Ref: EP/2/21HH

Description of Works: Erection of front extension to create first floor balcony, following demolition of existing conservatory with changes to external materials and wall finishes.

Location: 27A Sea Lane, East Preston, BN16 1NH

Front Elevation (west)

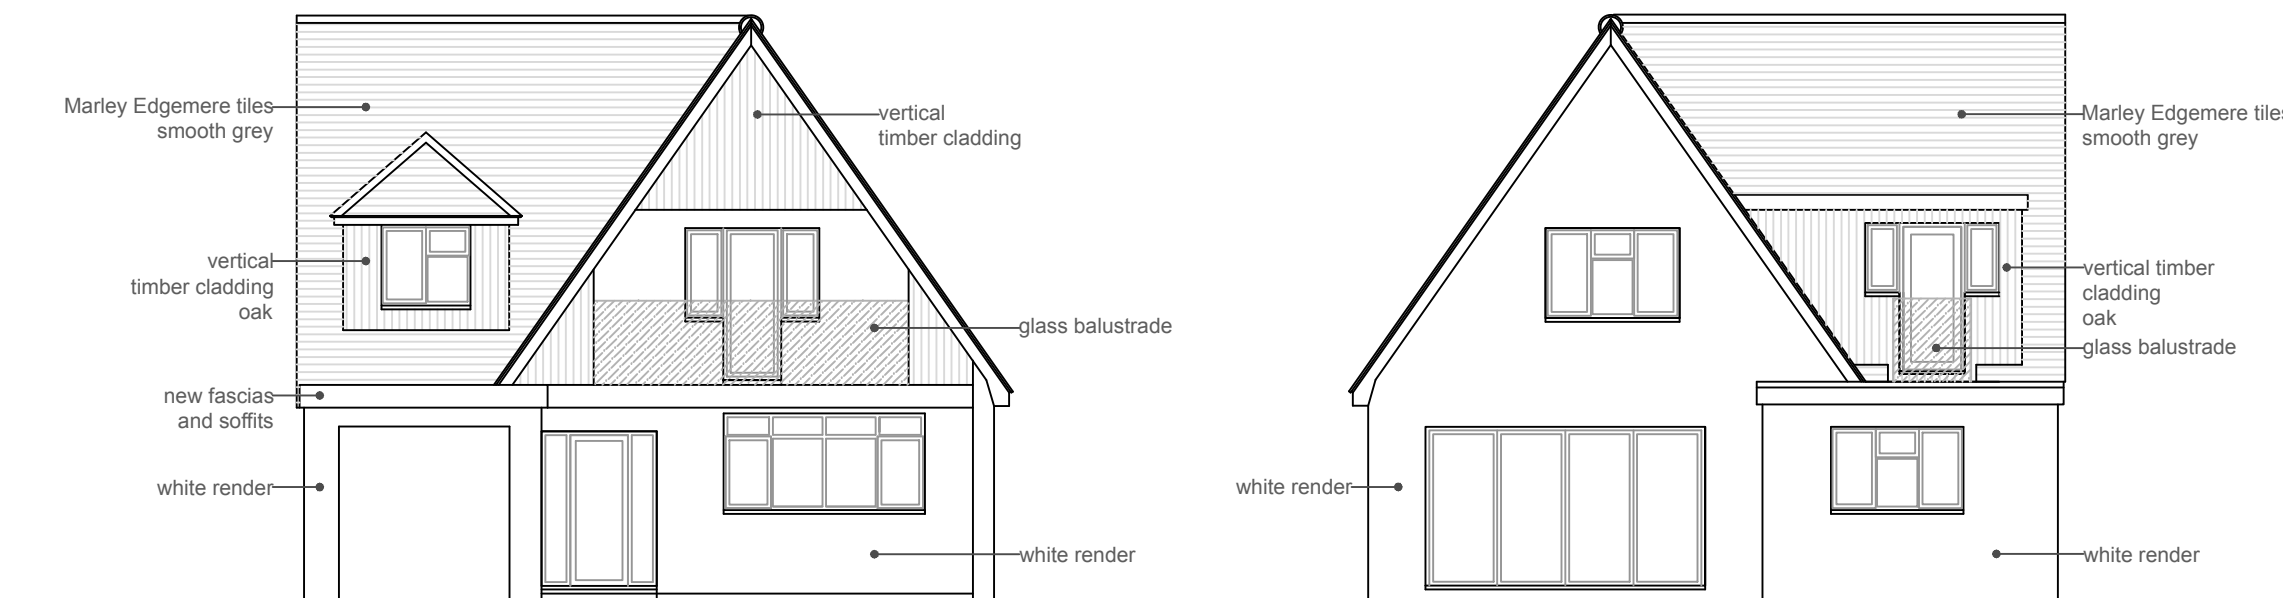
The proposed extension of the roof (west elevation) would also have an adverse affect on the view from my bedroom window and block out the little view I have of the sky.

Rear Elevation (east)

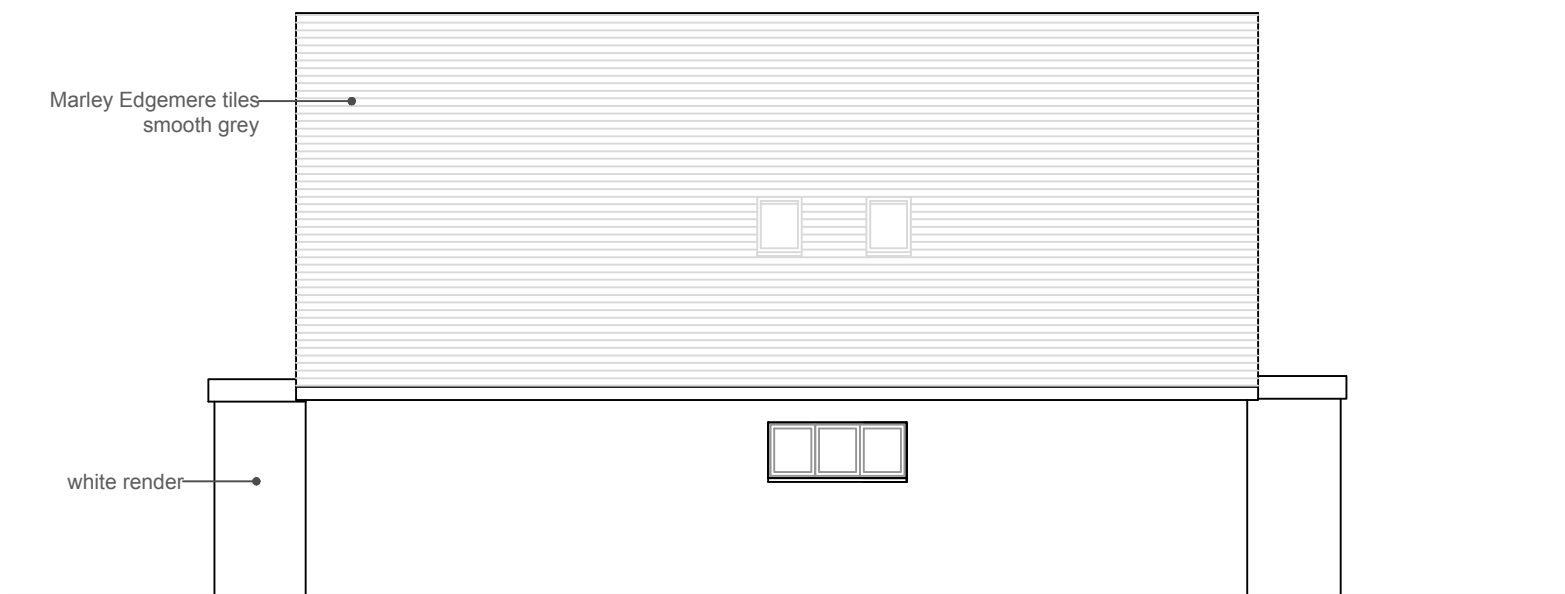
I am extremely worried about the proposed balcony to the east elevation (rear of 27a) in the above application.

I am in my nineties and live in the small annexe in my daughter's garden. The proposed balcony will completely overlook all of my sitting room from quite a close distance. My sitting room where I spend all my time has double patio doors facing south. People on the balcony would be able to look directly in on this space which is my only living area and at my age where I spend the whole day. This would be very unpleasant and distressing for me.

They would also be able to see into my kitchen window.
